S Harnett County - Application Tracking Individual Step Mai...

Application number 09 50022556
 Application type CP NEW RESIDENTIAL (SFD)
 Revision number
 Path/Step/Seq/Agency A 10 00
 Date submitted, resulted 81409
 Status code
 Reviewed by
 Revised est cpl date 81309
 Copies of plans

PLOT PLAN
 OF
LOT 6
JONATHAN RIDGE
HARNETT COUNTY
 FOR
SCOTT LEE HOMES

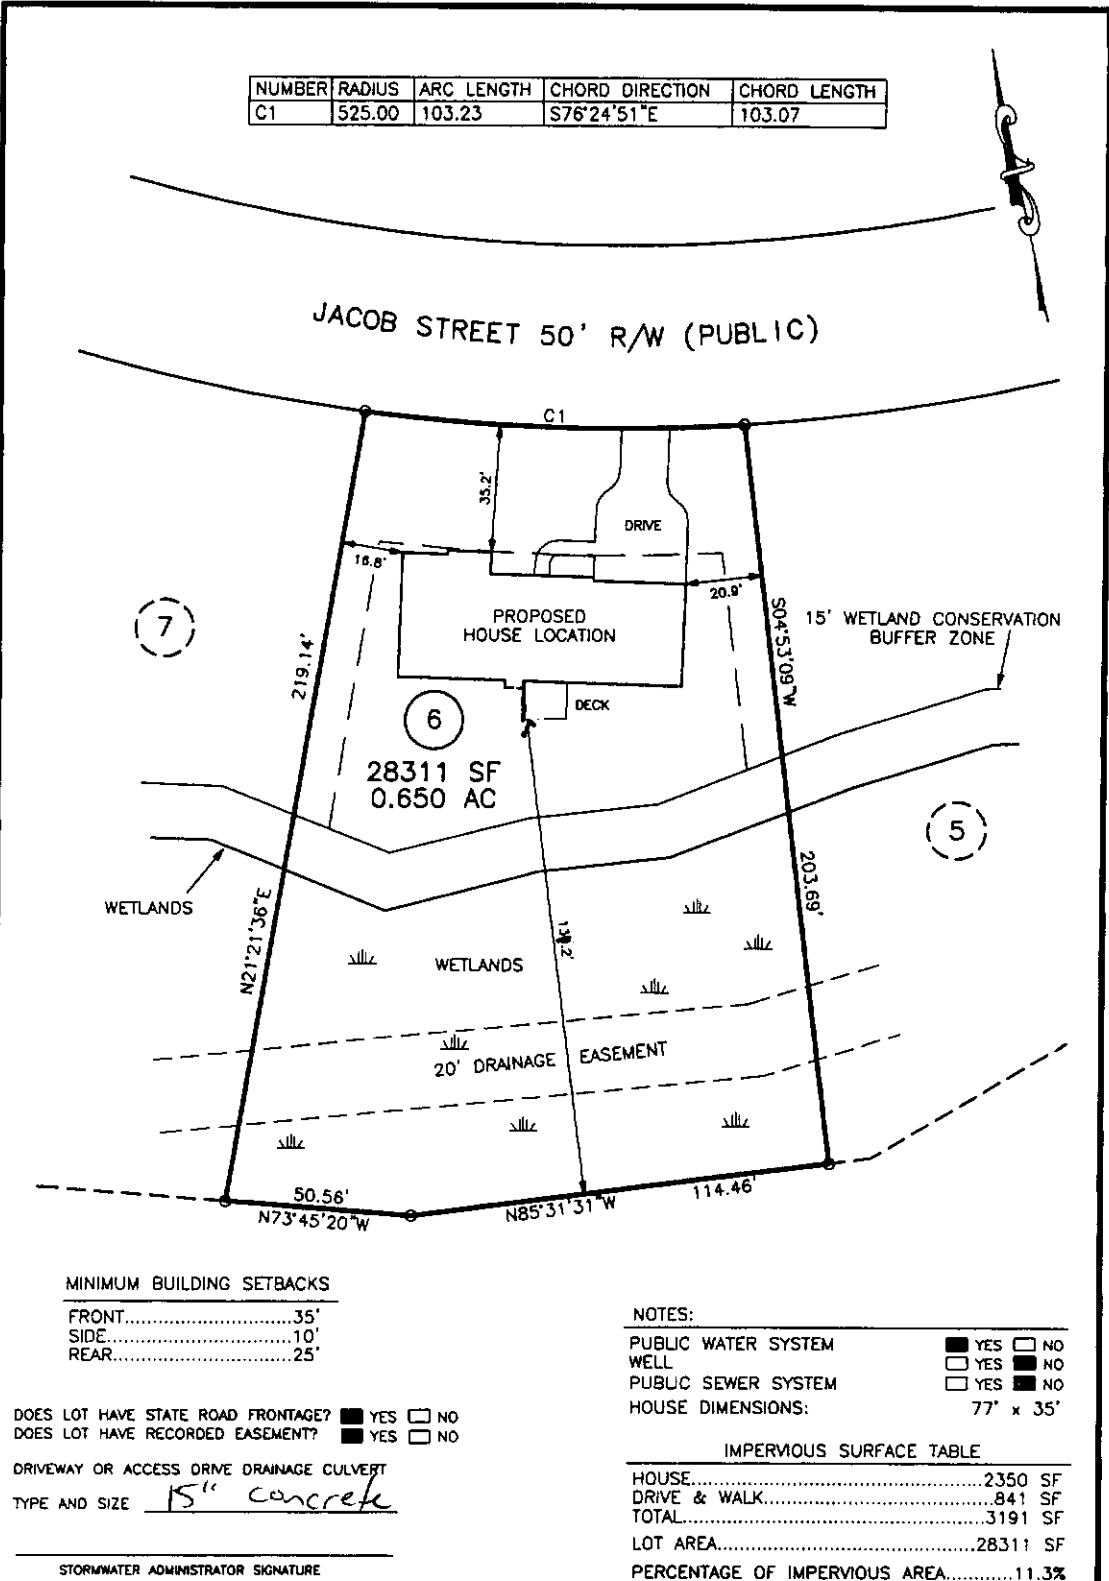
Seq	Comments	Prt	Date
1.000	RE-MARK BUFFER ZONES PER MAP. T/S: 08/14/2009 11:18 AM S STEWART -----		81409
2.000	T/S: 09/04/2009 11:08 AM S STEWART ----- CALL 893-7547 TO SCHEDULE A MEETING IN ENVH WITH JAMES MANHART TO SCALE OUT AVAILABLE SPACE FOR HOUSE PLACEMENT.		90409
3.000	ON HOLD PER BUILDER'S DECISION.		92409
